From: DataSpace Consult [system@dataspaceconsult.co.uk]
Sent: 05 February 2015 14:13
To: Planning
Subject: Comments Added: 43, Broadwater Road, Welwyn Garden City AL7 3AX -

Application ID: N6/2015/0034/MA - Mr T Allington Application Owner: Welwyn & Hatfield Borough Council(Development Management Officer)
Applicant: Woods Hardwick Planning Ltd
Location: 43, Broadwater Road, Welwyn Garden City AL7 3AX -
Deadline Date: 20/02/2015 00:00:00
Description: Erection of 23 dwellings with associated access, landscaping and ancillary works
Comment Added:

Plan

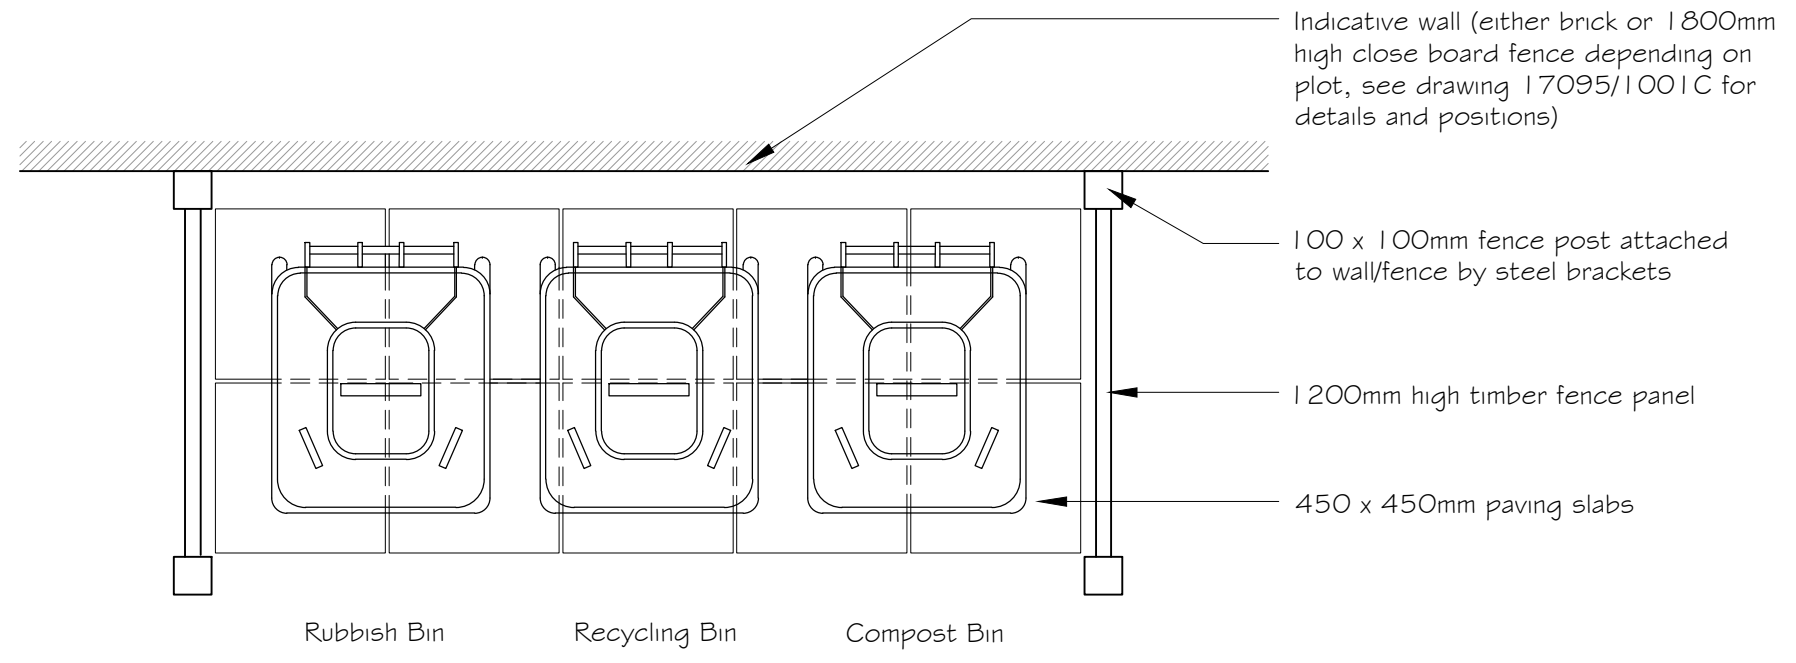
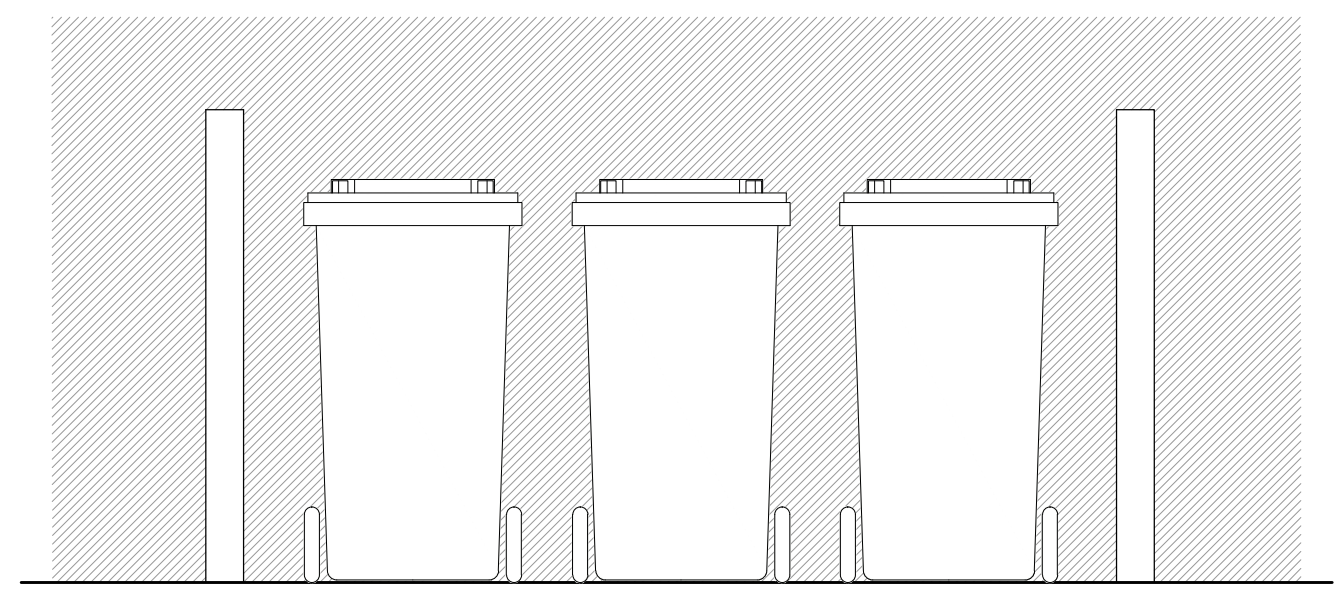
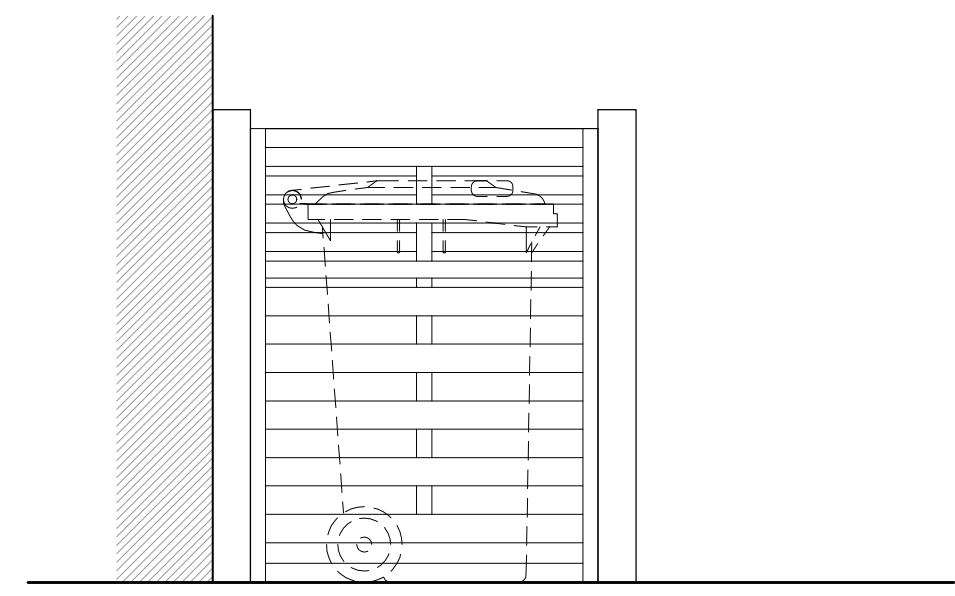
Looking at the plans, it appears that there is to be one bin store to service all properties.

if this is correct then the requirements will be for 5 x 1100litre containers to be emptied weekly at cost of [REDACTED] per container and 1 x set of mini-banks emptied fortnightly at cost of [REDACTED]. Please note: I would strongly recommend you consider whether or not to place recycling facilities inside the bin store. Unfortunately if these banks become contaminated they will not be able to be emptied by our contractors and the management Company will have to pay to have them cleared or to arrange to clear themselves. not everyone shares the same ethos as far as recycling is concerned and when you have flats this can be an issue. in addition please bear in mind no excess or bulk items will be removed from the bin stores, any excess rubbish will again have to be cleared by the management company.
